**M42 Junction 6 Improvement  
TR010027**

**5.2 Annex P: Responses to  
Consultation and Demonstration  
of Regard Had to Responses**

## 5.2 Annex P: Responses to Consultation and Demonstration of Regard Had to Responses

## Annex P (Part 1): Tables evidencing regard had to consultation responses (in accordance with s49 of the Planning Act 2008)

Drawing Number Highways England PIN HE551485 -ACM	Originator -EGN-	Volume DCO-9006	Rev C01
Location M42_SW_ZZ_ZZ		Type -DR-	Role DCO

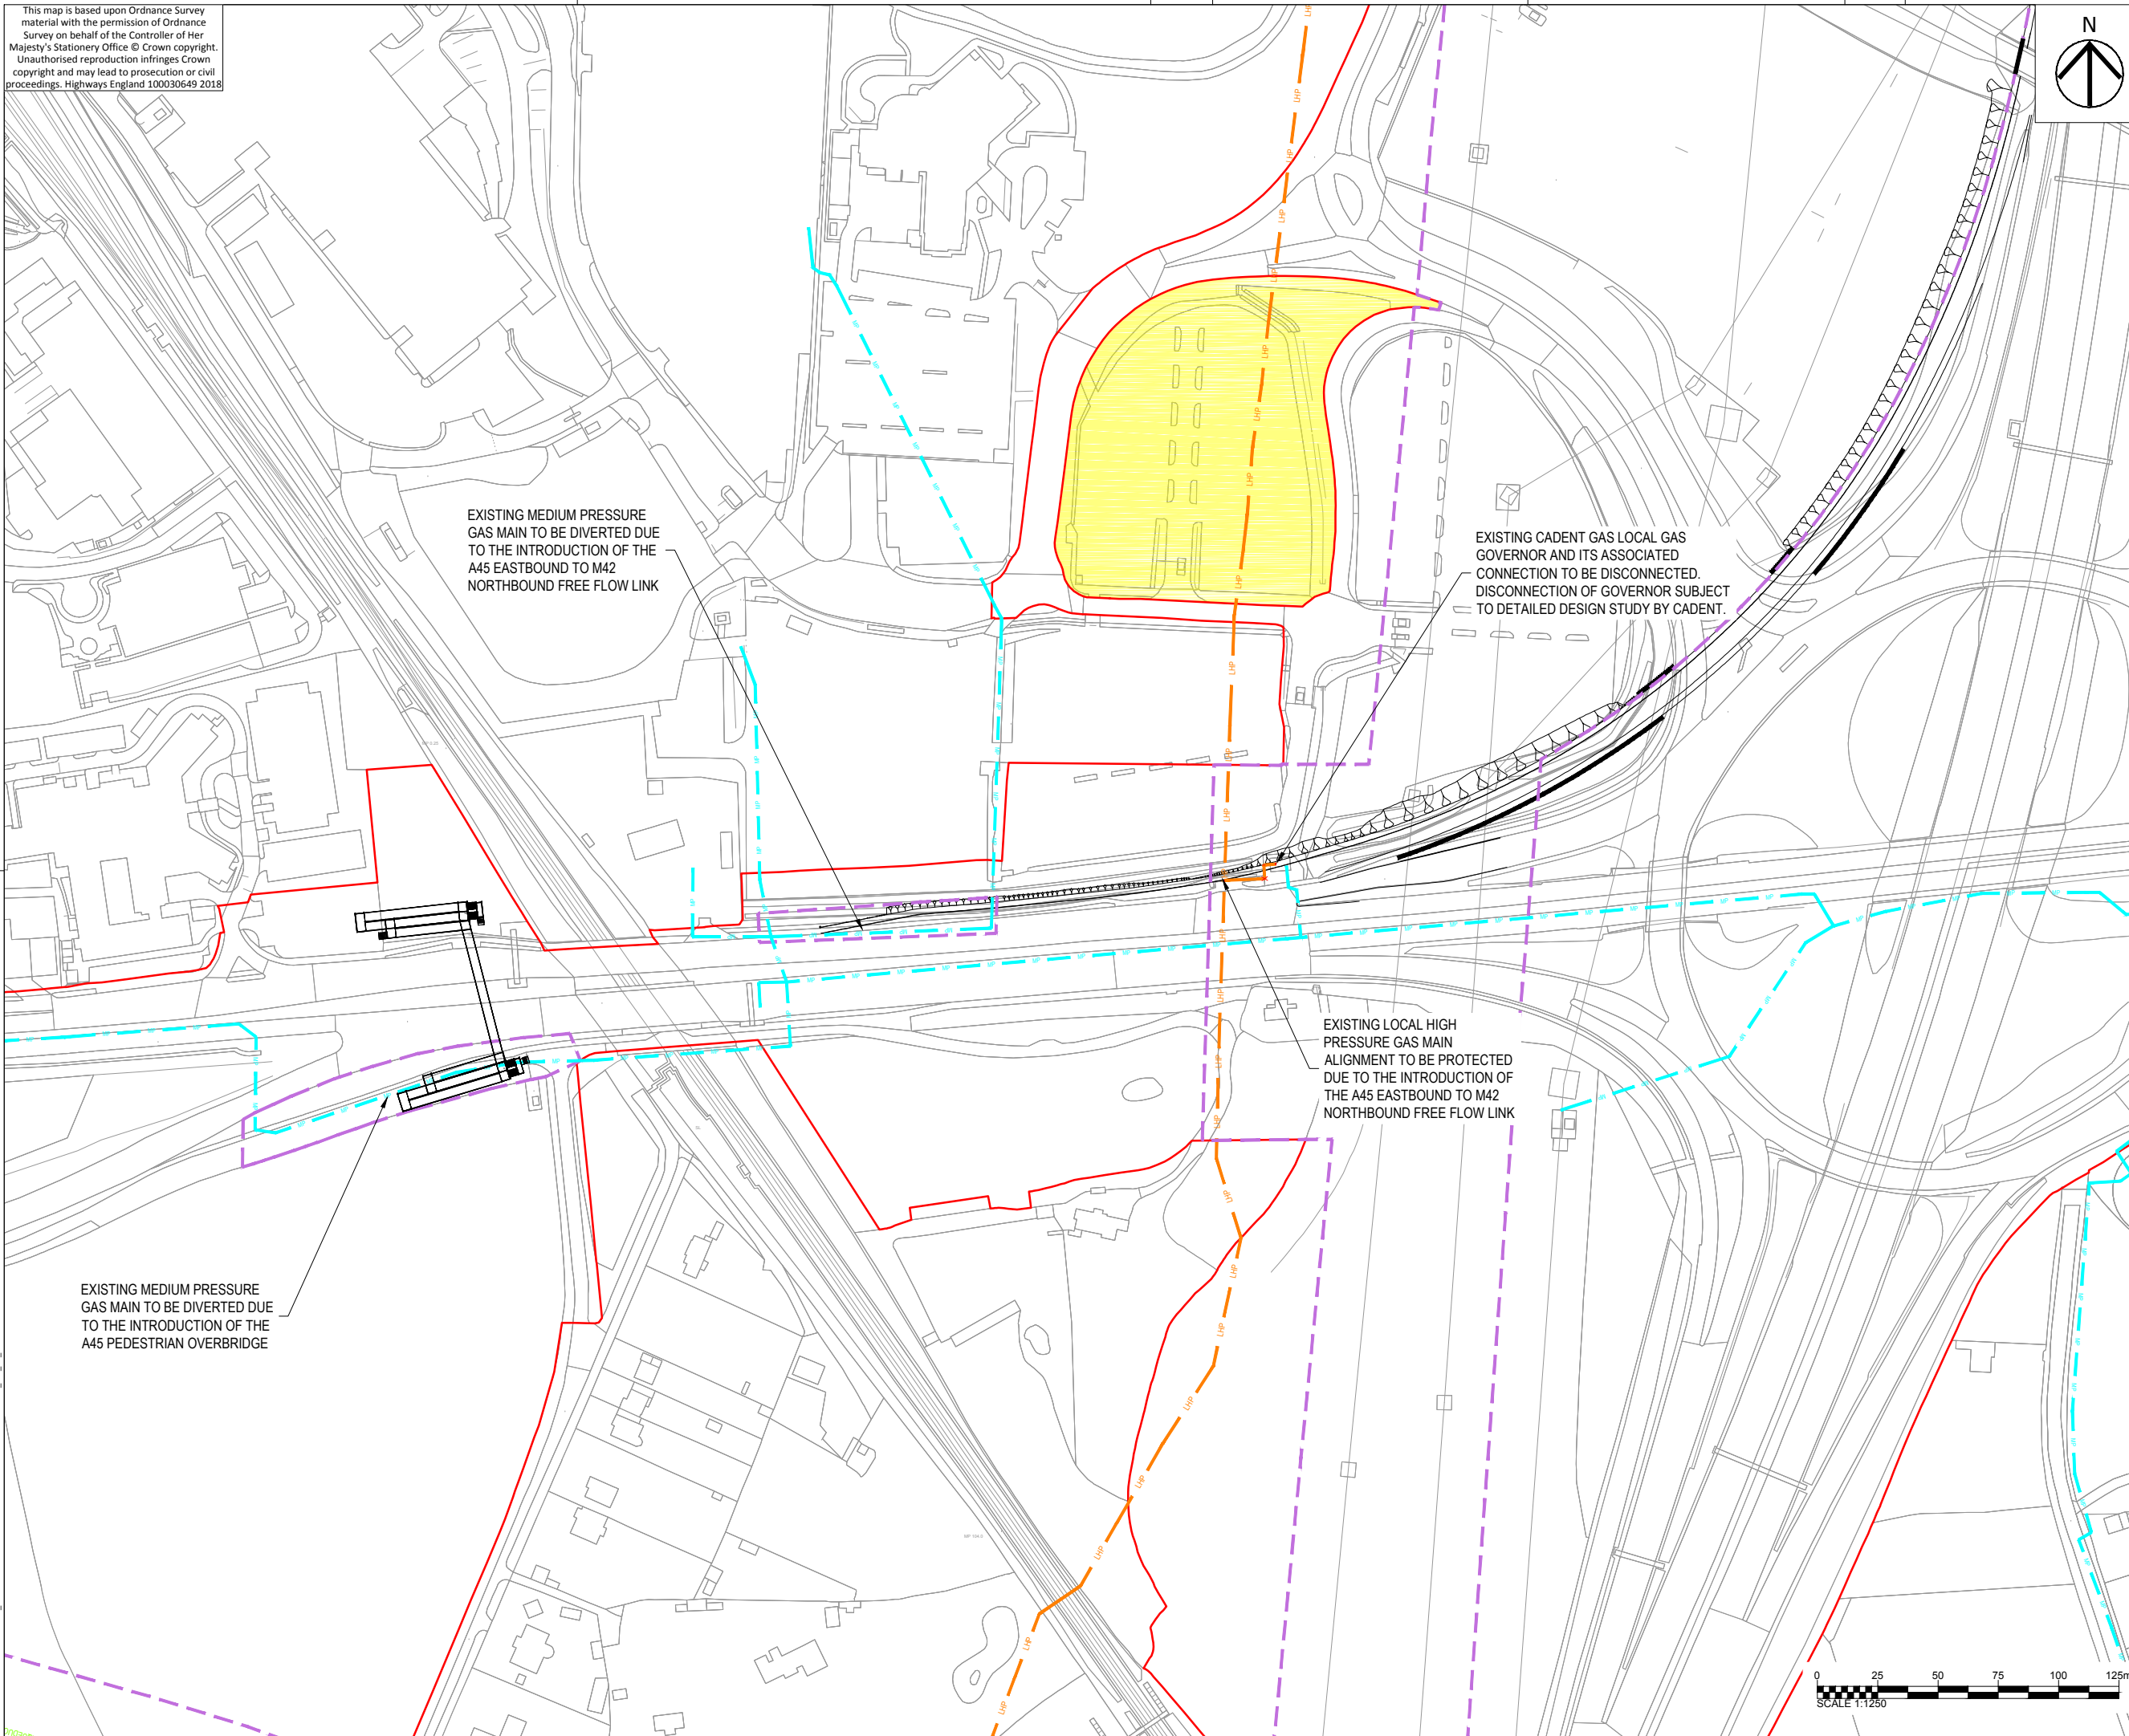
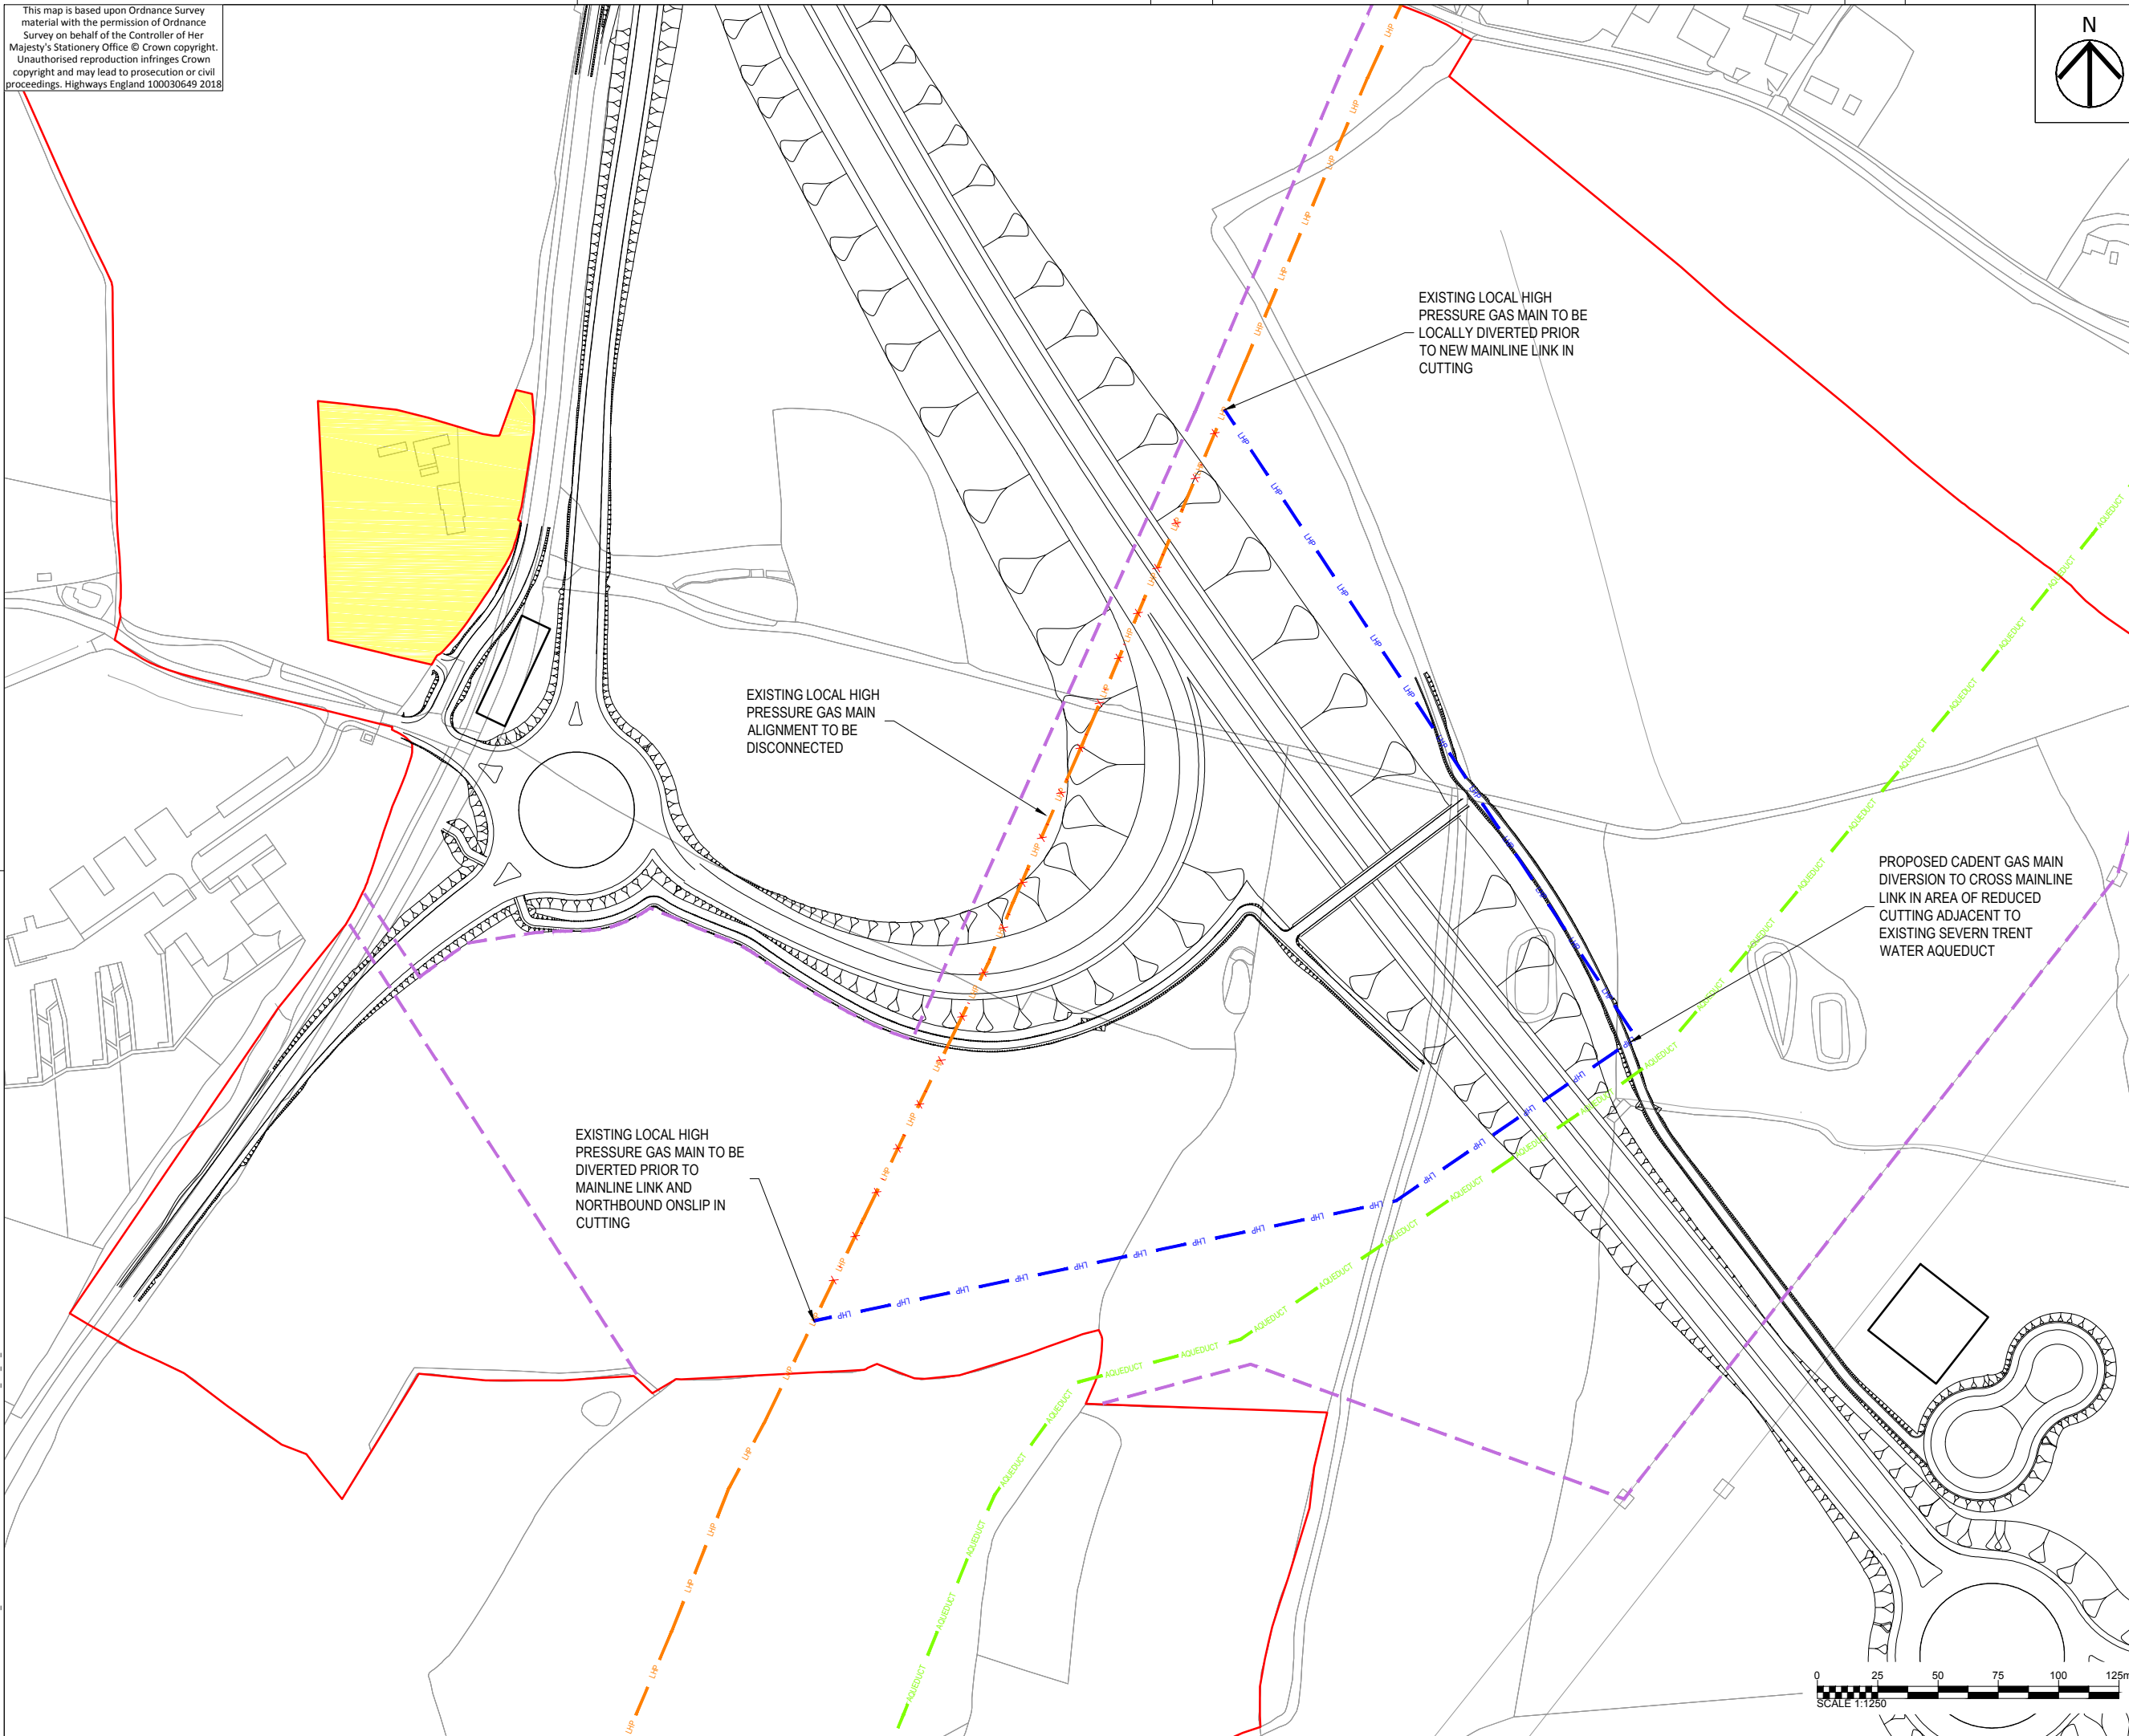
Gas governor	Consider moving gas governor on the A45 E during the preliminary design phase as this is a pinch point location.	SMBC	N	<p>This is noted. Moving or de-commissioning of the gas governor is included in the design and the relevant powers to implement this are being sought in the DCO. Discussions with Cadent Gas are ongoing.</p>
North-facing slips	Whilst we have received some reassurance that there will be further	Coventry and Warwickshire	N	<p>North-facing slips at Junction 5A are not included in the Scheme. During design development Highways England’s</p>
